I made a verbal representation to the planning inspector at Duston Hall during which I explained my fear for my safety whilst riding near my home if the plans go ahead.

I live at [REDACTED] East Pye is proposing a construction compound on [REDACTED] at the bottom of our private driveway which is also a byway, and part of Boudicca Way Long Distance Route. The byway crosses [REDACTED] and travels along the side of the proposed compound. Where the byway crosses, it is a very narrow part of the road with blind bends. The currently quiet byway at the far side will not be the same with a construction compound adjacent.

Figure 4.2: Indicative Temporary Construction Compound Locations

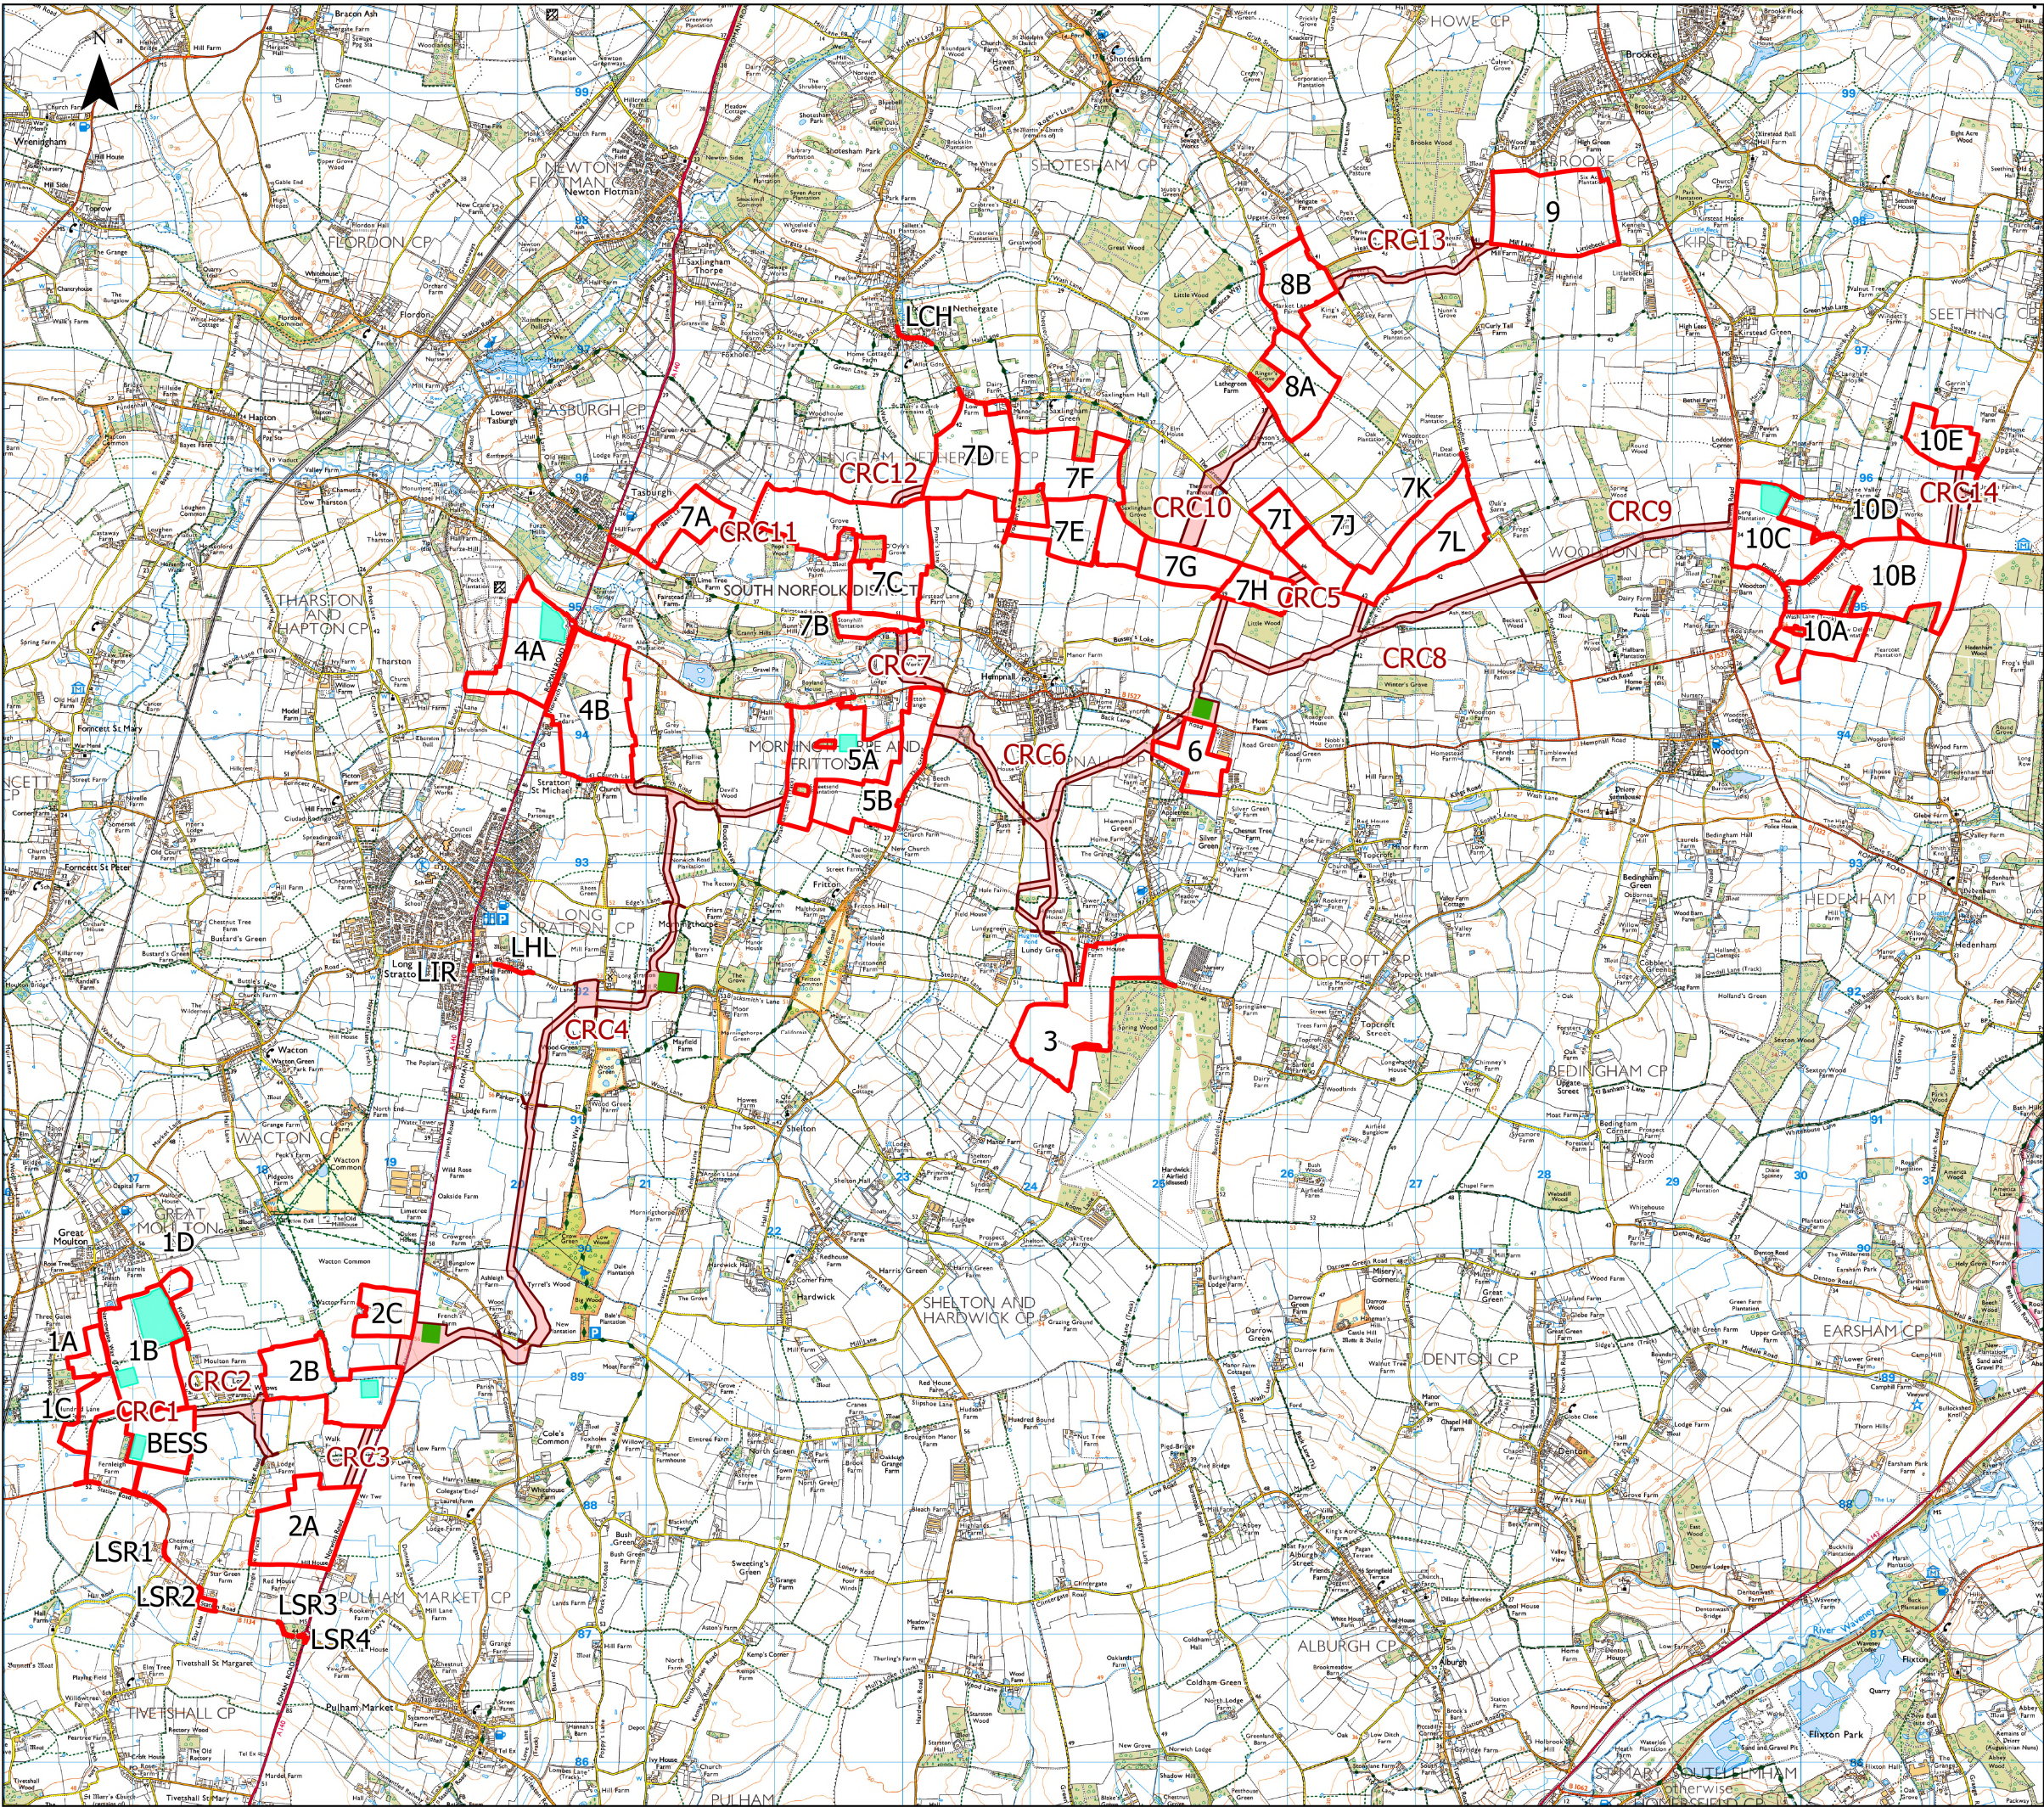
East Pye is proposing a second compound on Hall Lane where it meets [REDACTED]. This is currently a z bend.

It is worth noting that East Pye has submitted plans which do not currently show the bypass or the new bridge on Hall Lane, which is not wide enough or suitable for construction traffic. Due to the quiet nature of the lane, the bridge is narrow with a multiuser path to one side.
